Your Ref: OWPC18381
Our Ref: A/8/18/PL 26-01-2018
Please ask for:
Mrs A Gardner

Variation of condition 2 imposed under A/173/16/PL to read 'the development to be carried out in accordance with the following approved plans ADC 962/04 REVA, ADC962/13 & ADC962/14 relating to slight repositioning & change in size of building, revised position of rooflights on east, north & south elevations. This application affects the character & appearance of the Angmering Conservation Area.

Land Rear of 1 To 6 The Cottrells Angmering

A		Layout amended		10.11.17	
Rev		Description		Date	
Job Reference		Client			
New House The Cottrells Angmering, BN16 4AF		AM Homes Ltd			
Drawing Title		Drawing No		Rev	
Ground Floor Plan		ADC962/04		A	
Date	Scale	Dwg Size	Plot Style	Drawn	Checked
24.04.17	1:100	A3	ADC-red	TGS	AD

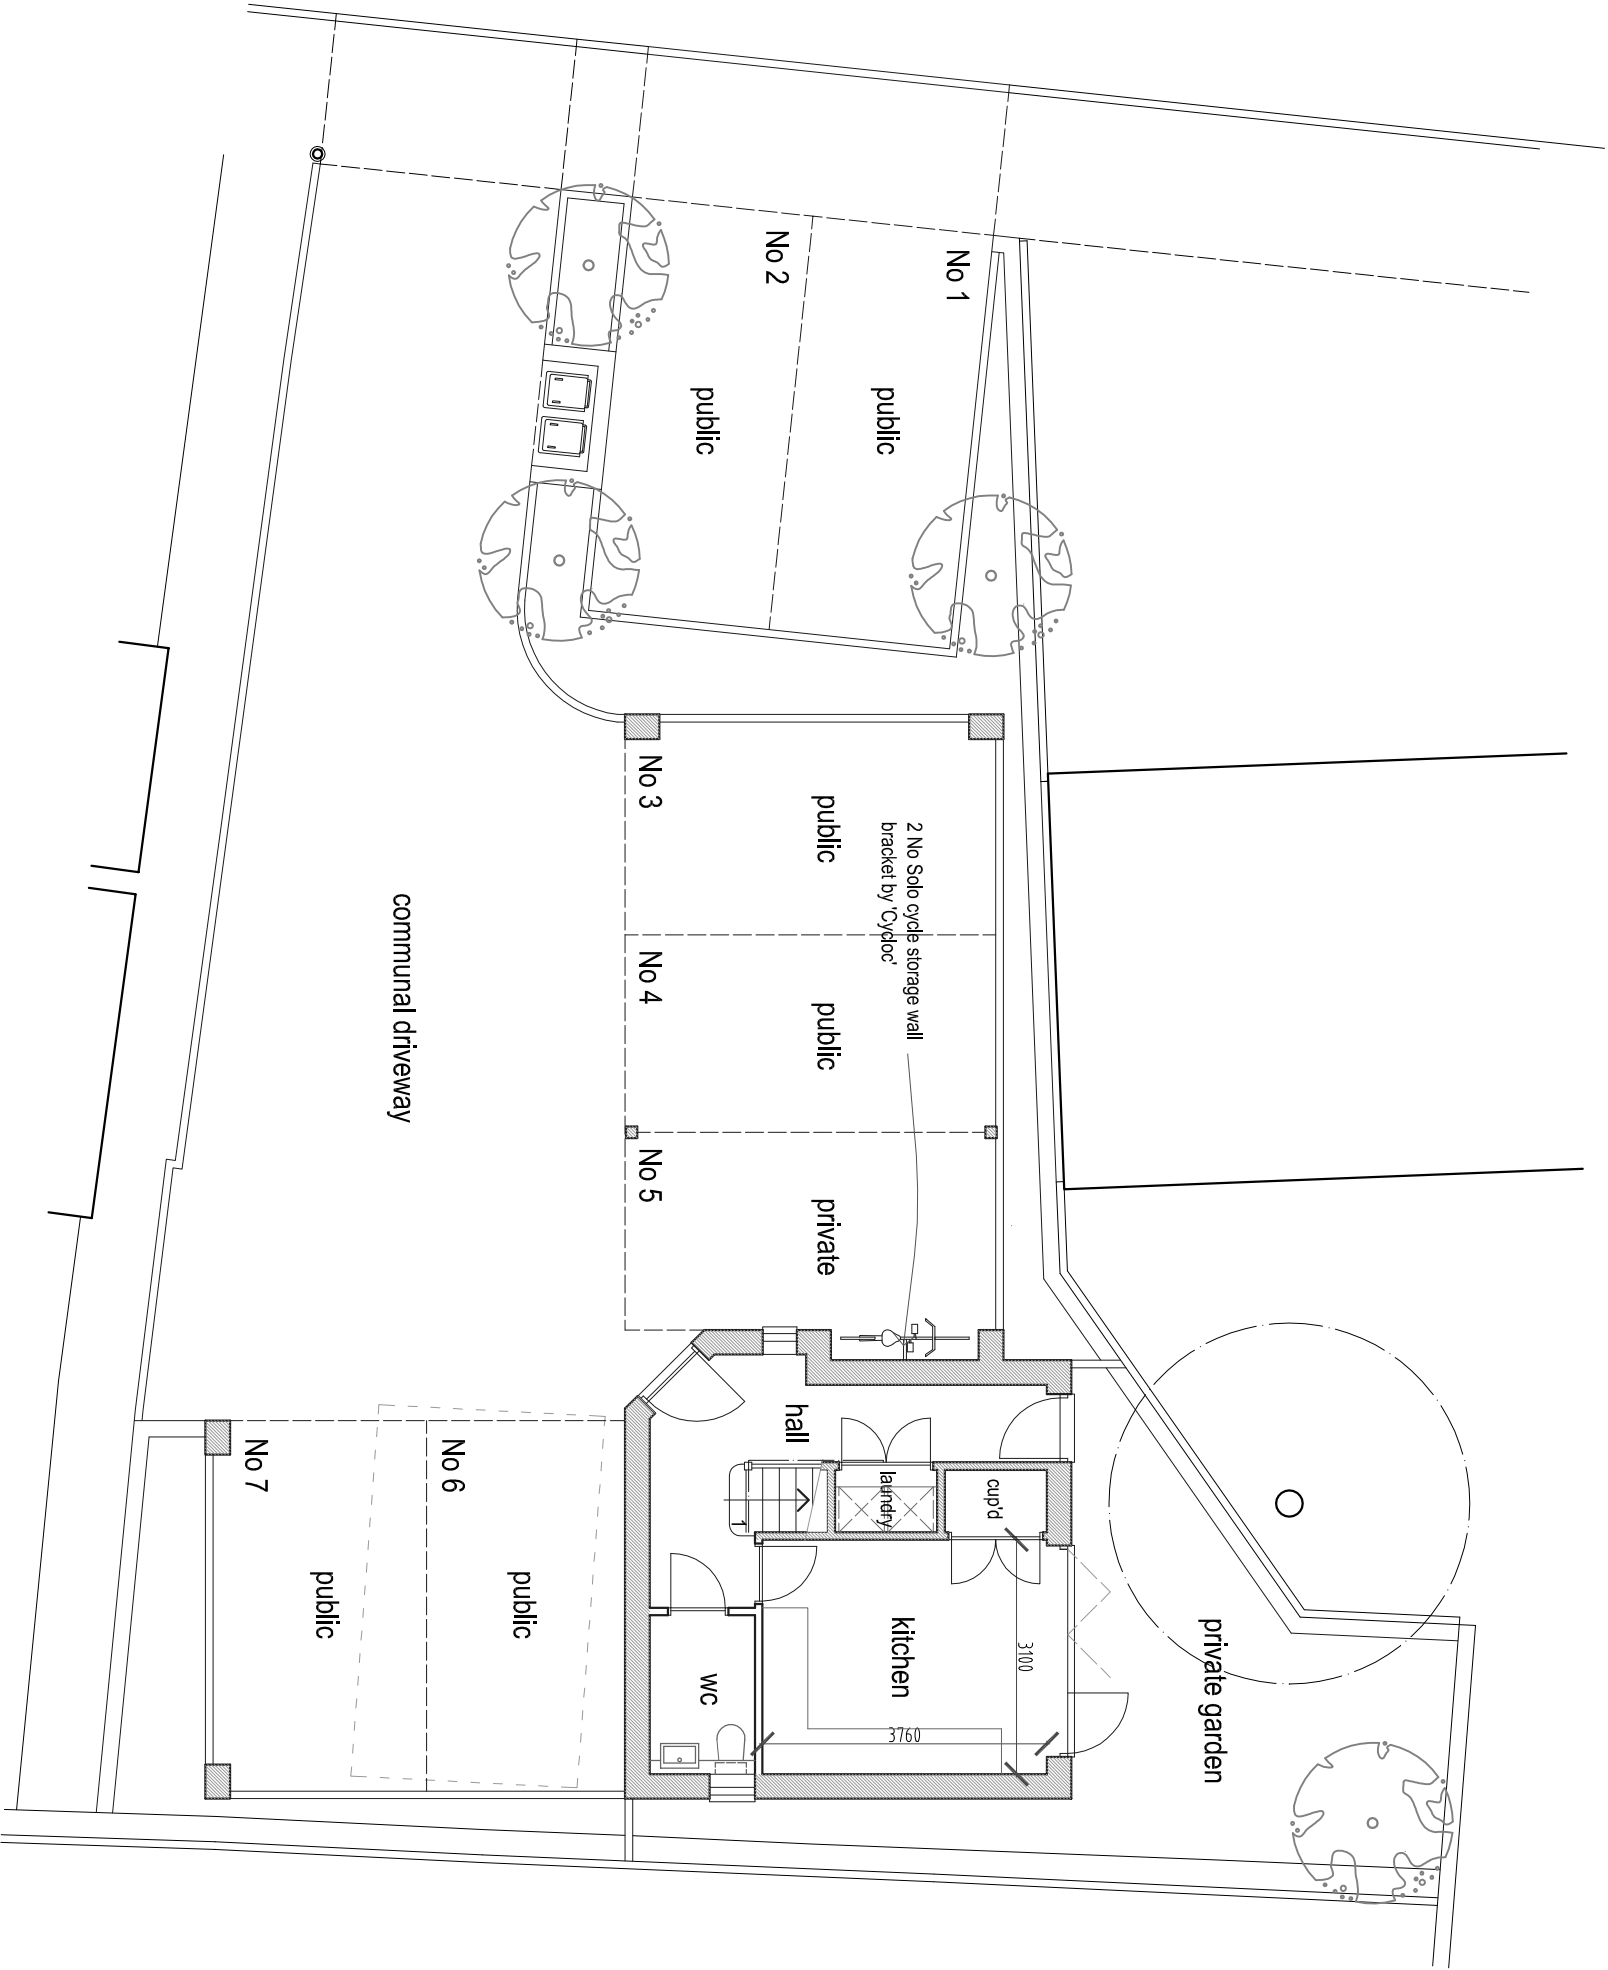
- 2. The increase in overall size of the building means that it is built on land that the developer does not own (the alleyway at the back of nos 1-5 The Cottrells) . The wall that the builder has built on the alleyway has also restricted the use of a drain cover.*

- 3. No mention on the above variation has mentioned the internal layout of the property which has been approved as a 2 bedroom property with a downstairs kitchen (as shown on the variation plans), limiting the likely need for car parking to one car. The builders, I understand, have installed the kitchen upstairs and the downstairs room is an 'occasional' room ie bedroom. The parking in The Cottrells (and The High Street which is used as overflow parking for The Cottrells and other nearby properties) is already more than fully used and a 3 bedroom property would add to this problem.*

Rev	Description	Date
Job Reference New House The Cottrells Angmering, BN16 4AF		
Client AM Homes Ltd		
Drawing Title First Floor Plan & Roof Plan		Drawing No ADC962/13
Date 16.01.18	Scale 1:100	Dwg Size A3
		Plot Style ADgrey.spl
		Drawn AD
		Checked AD

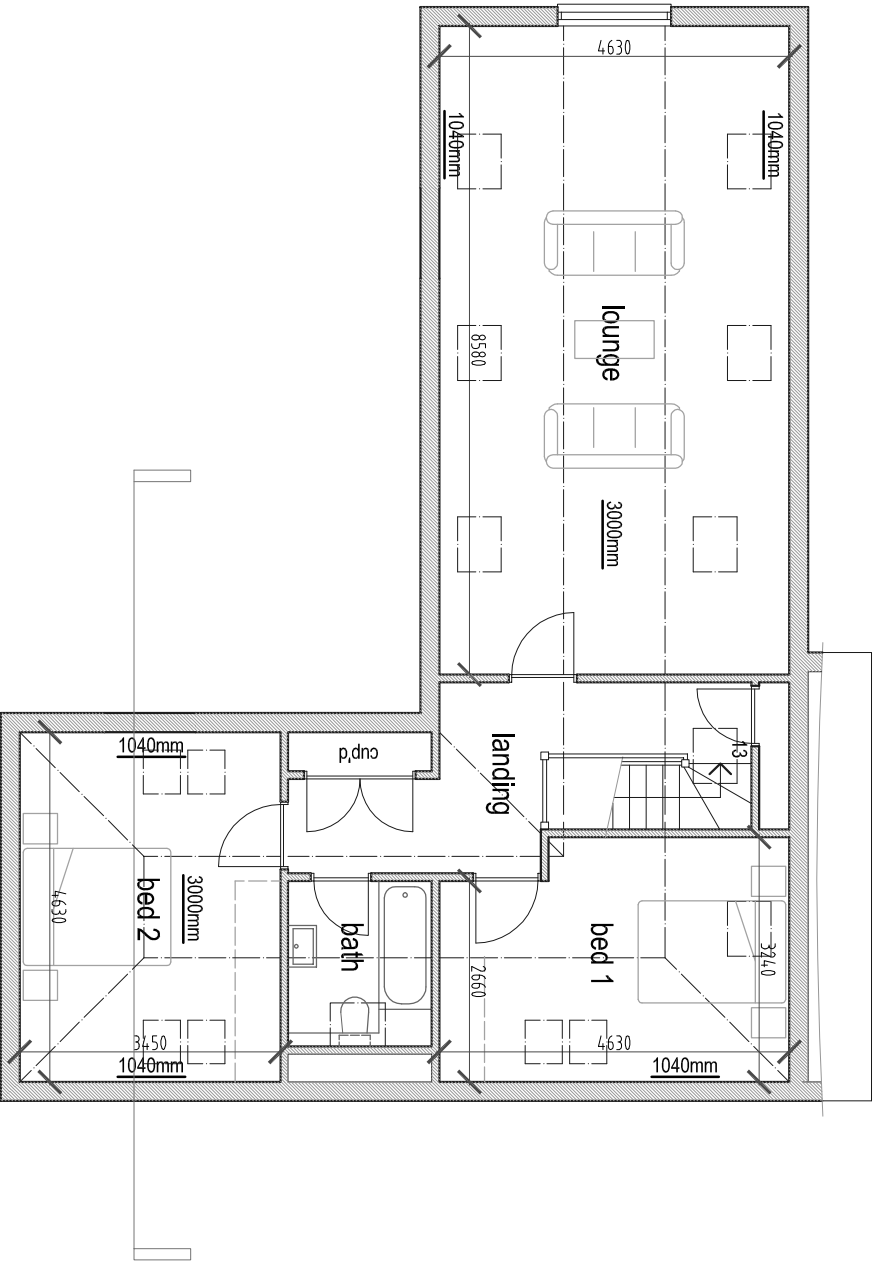
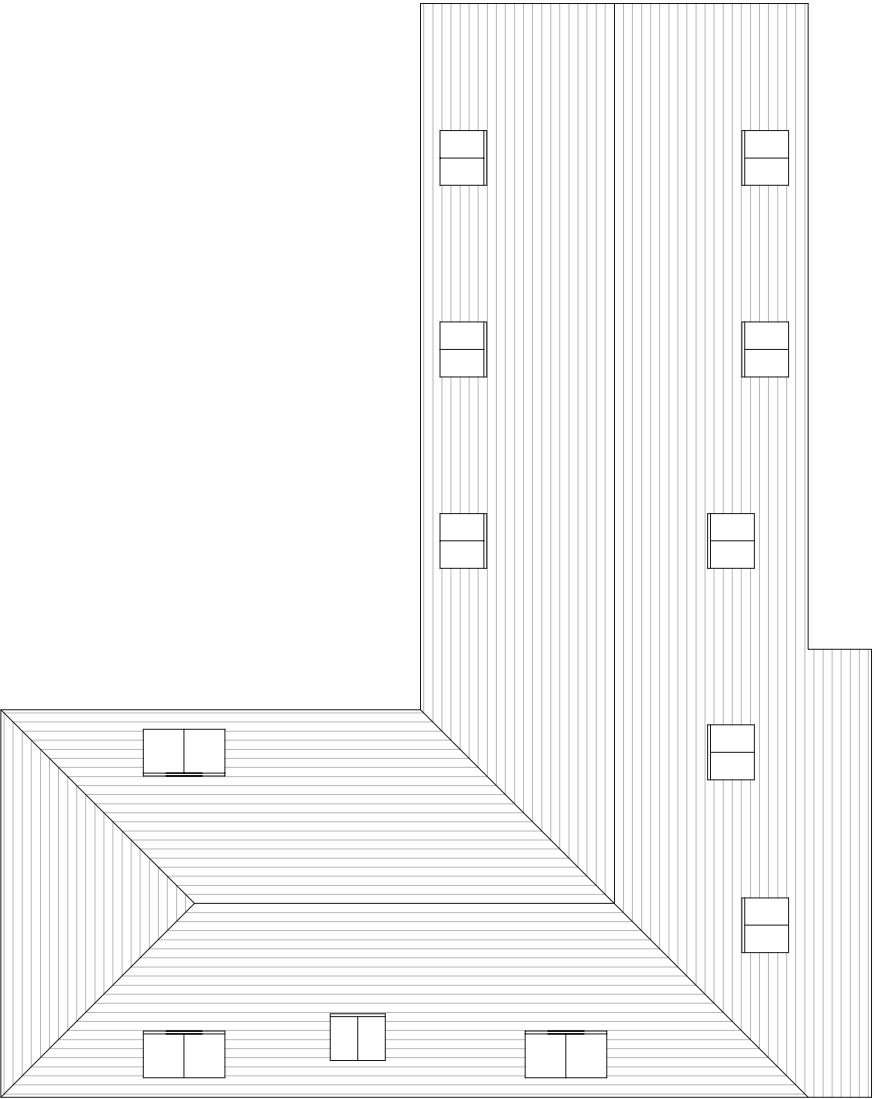
- 1. The rooflights (which should be emergency exits as per planning approval) appear to be windows on the actual building and as such are contrary to what was originally granted planning permission. These windows are at the same height as the bedroom and bathroom windows of nos 2-5 The Cottrells which means that there is no longer any privacy for these rooms and particularly to the back bedrooms. If these emergency exits are to remain could they be of obscured glass to mitigate this.*
